Re: State Significant Development Modification Application - SSD7155 MOD 2

We refer to the letter dated 18 September 2017 prepared by LOGOS Property (the applicant) in relation to the proposed State Significant Development (SSD7155) for the Prestons Warehouse and Distribution Estate. This letter was referred to Liverpool City Council on 22 September 2017 for comment.

Please find below Council's response in relation to the changes proposed to the original consent conditions.

SITE PLAN  
1: 1200 scale

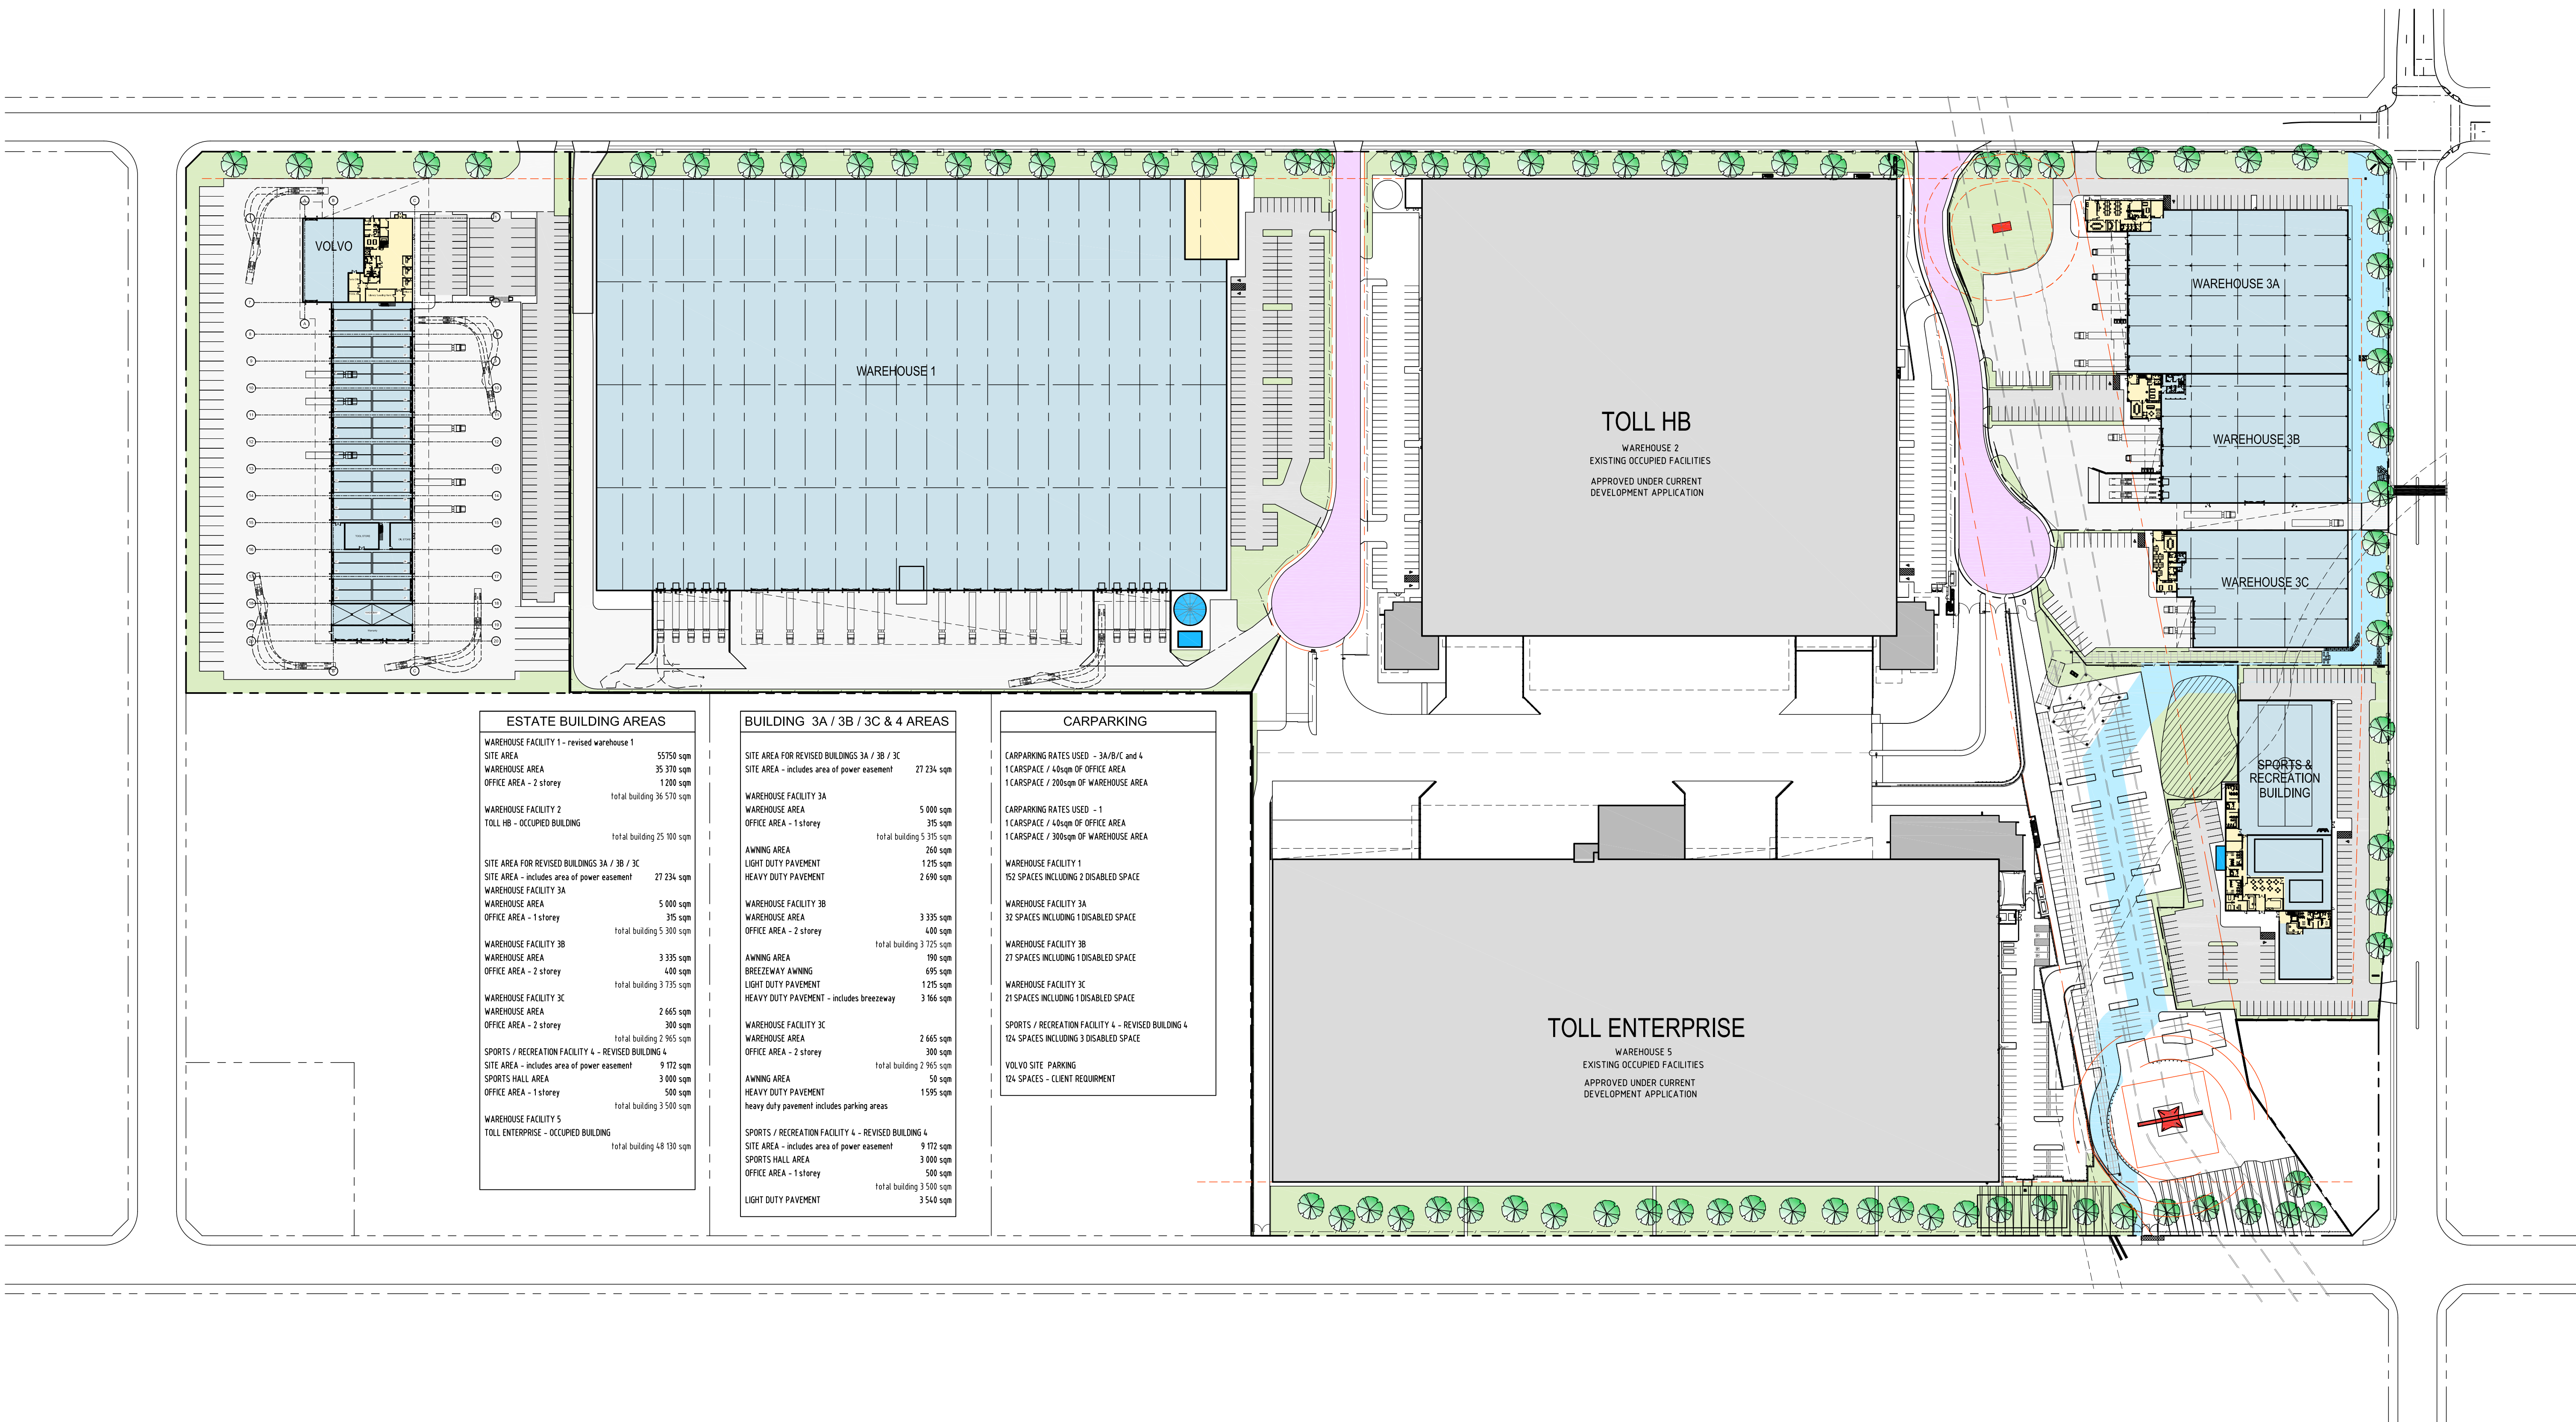
The proposed additional heavy vehicular access off Bernera Road with a central median (Drawing No: S96-A103) is not supported by Council. The access shall be via the private access road 2.

- The proposed upgrade at Bernera Road/Yarrunga Street intersection and its widening affection on the subject site;
- The section of Bernera Road between Kurrajong Road and Yarrunga Street to be widened to a 4-lane road;
- The relocation of the existing RMS VMS sign;
- Removal of the proposed additional heavy vehicular access off Bernera Road and the associated central median.
